Recommendation Report for Planning Permission

REF NO: FG/37/17/PL

LOCATION: Onslow Caravan Park
Onslow Drive
Ferring

PROPOSAL: Demolition of 3 No. buildings & erection of replacement workshop & machinery store (resubmission following FG/161/14/PL).

Project Name and Address
Floor Plan & Elevations
New Storage Barn
Onslow Caravan Park
Ferring

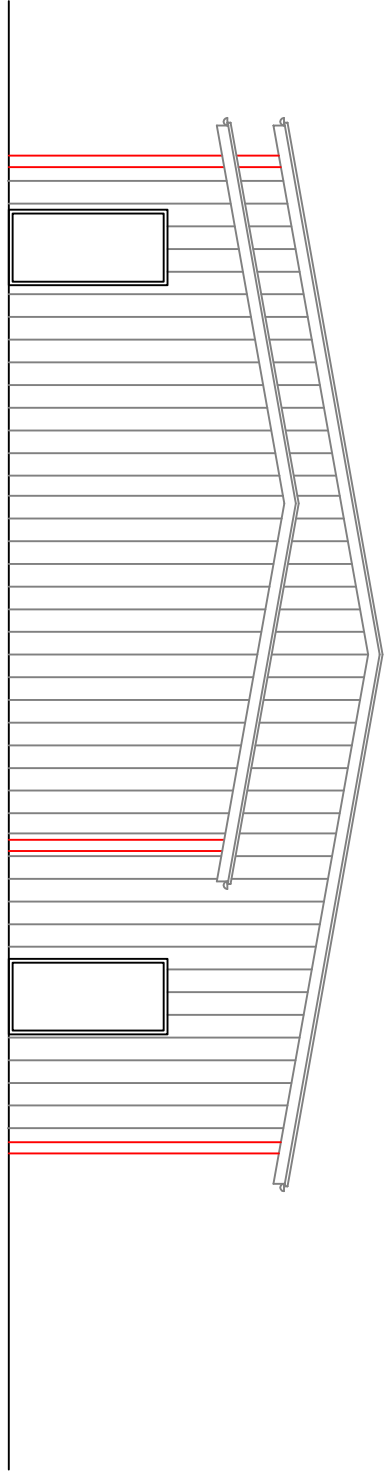
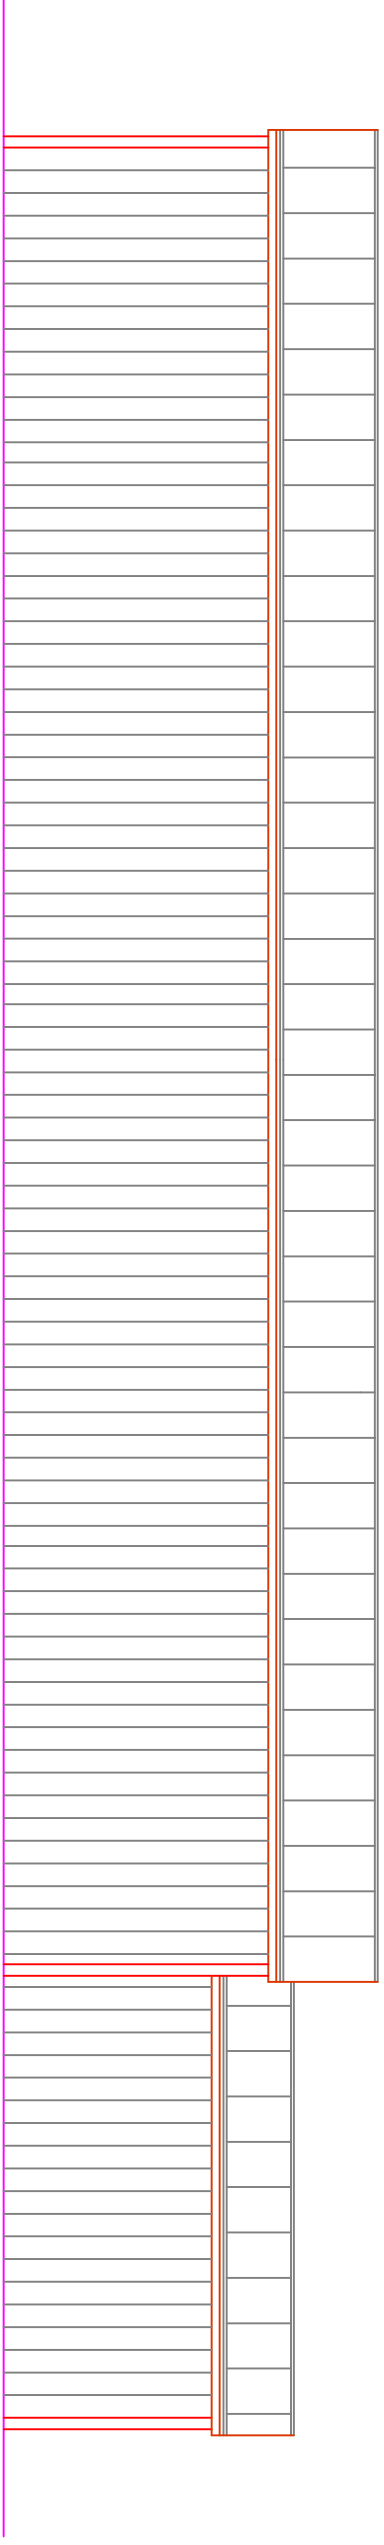
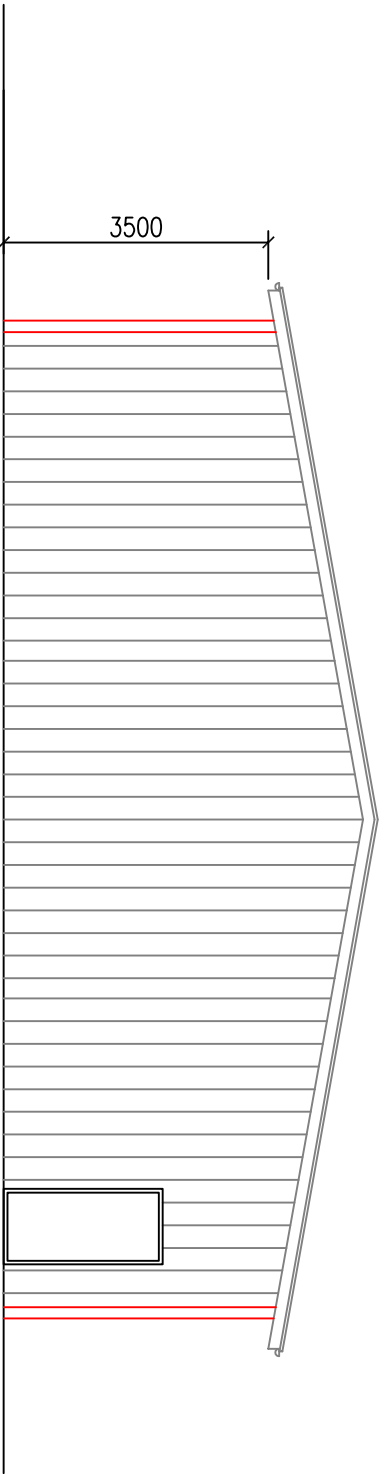
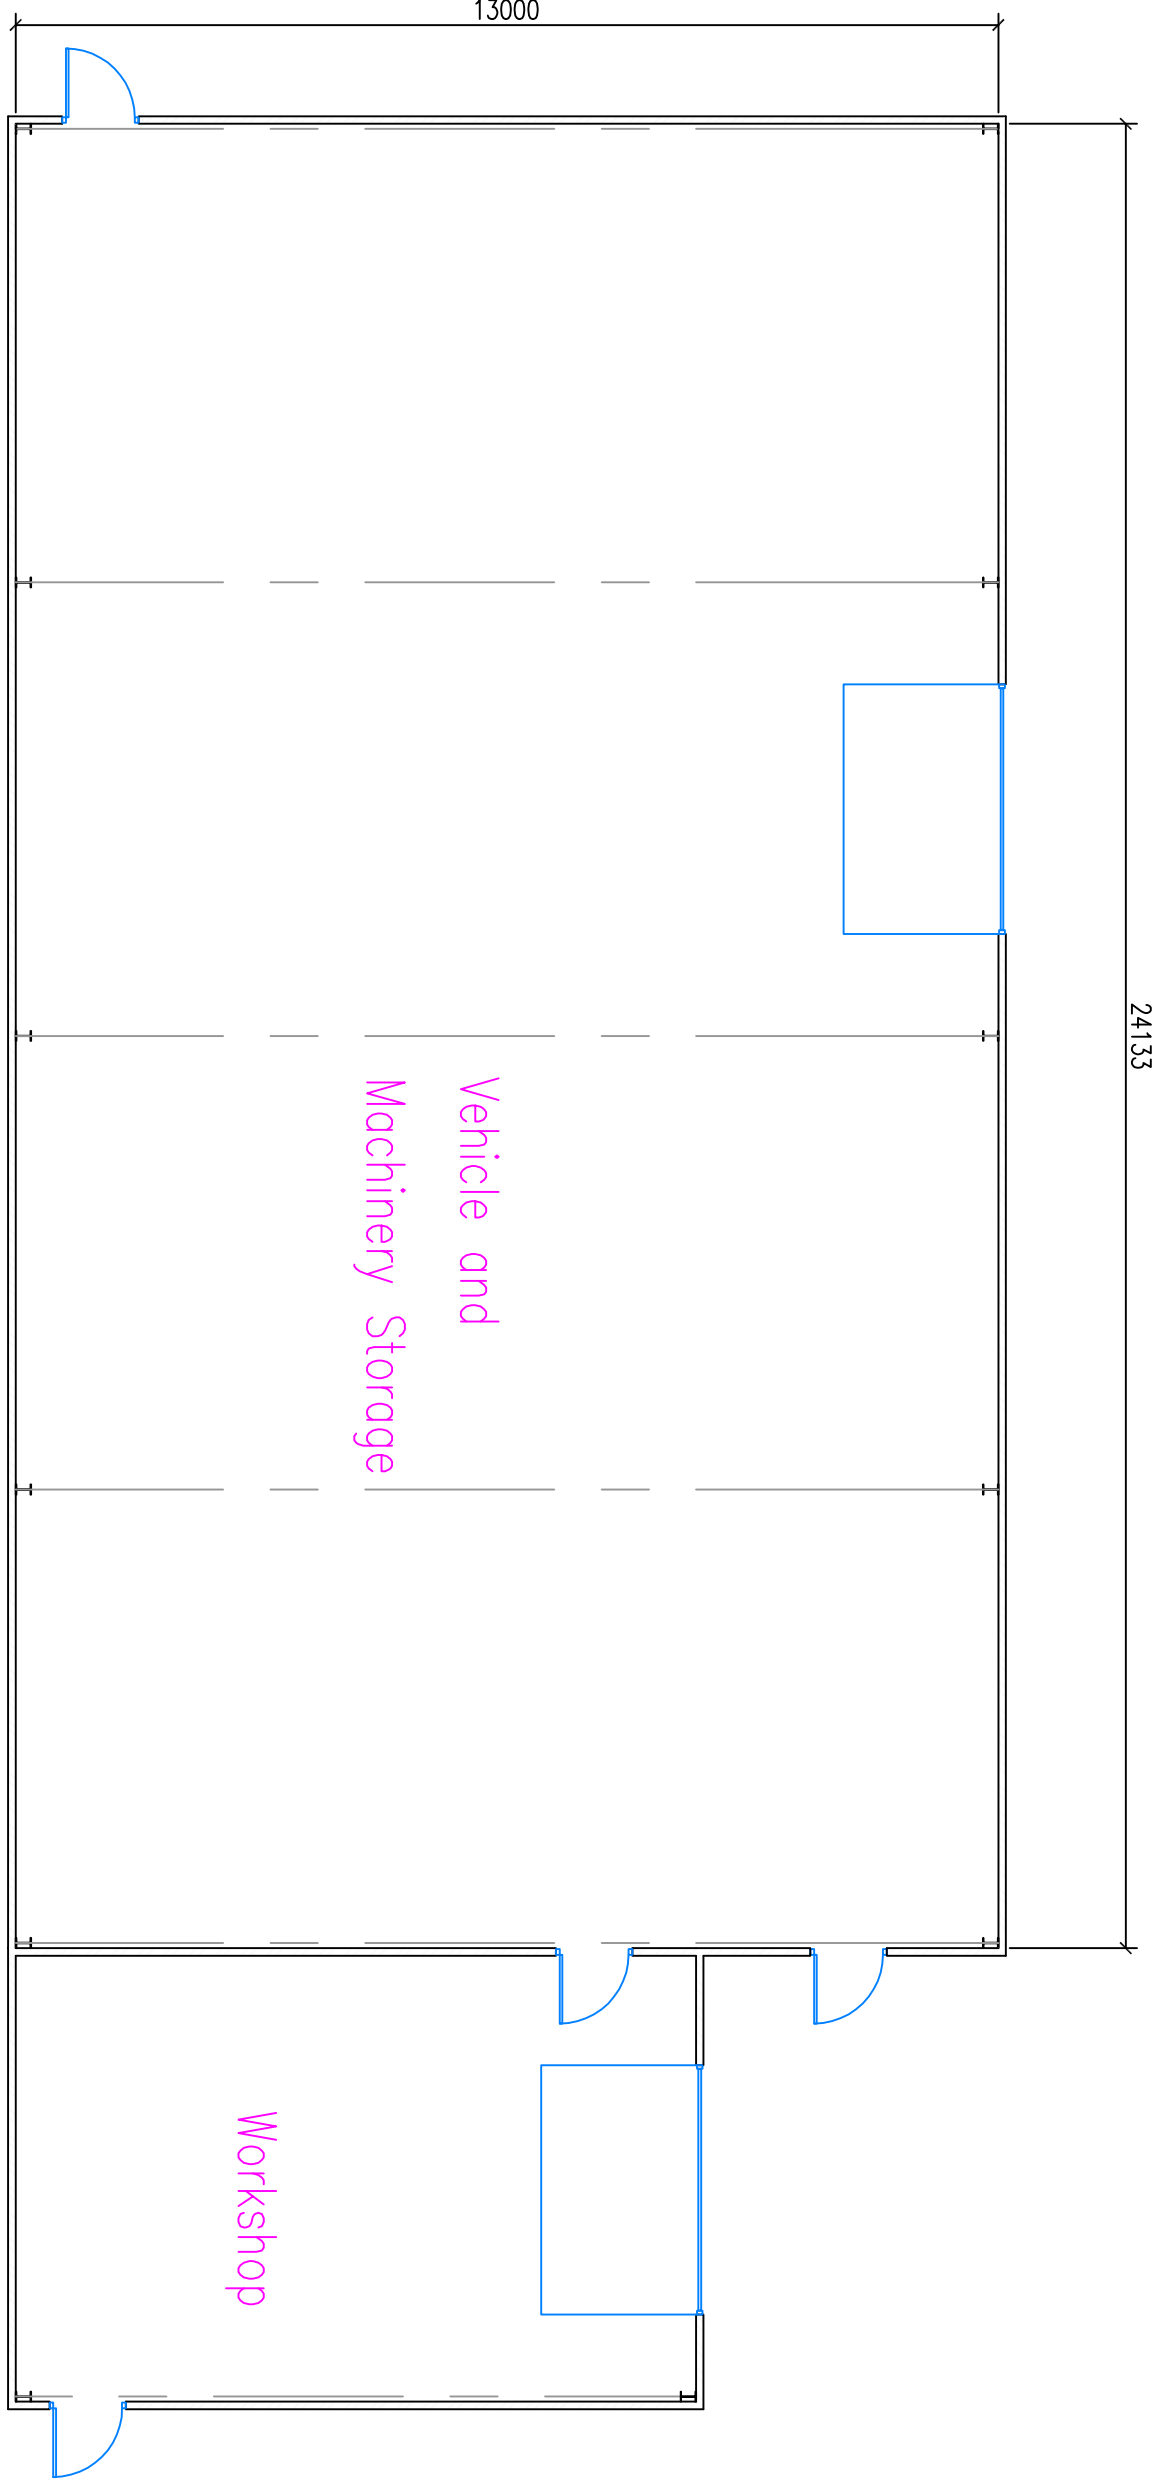
Network Rail -We note that on the plan the new building appears to be in very close proximity to the Network Rail boundary. We request that any building should be situated at least 2 metres from Network Rail's boundary. More detail is given below together with other criteria the developer should take into account in both the design and construction and future maintenance such as scaffolding, piling, plant and materials, drainage, and fencing.

We also note that the new building is over the culvert that runs under the railway. We would recommend the developer ensures that there are no covenants or restrictions as to building over the culvert in that area.
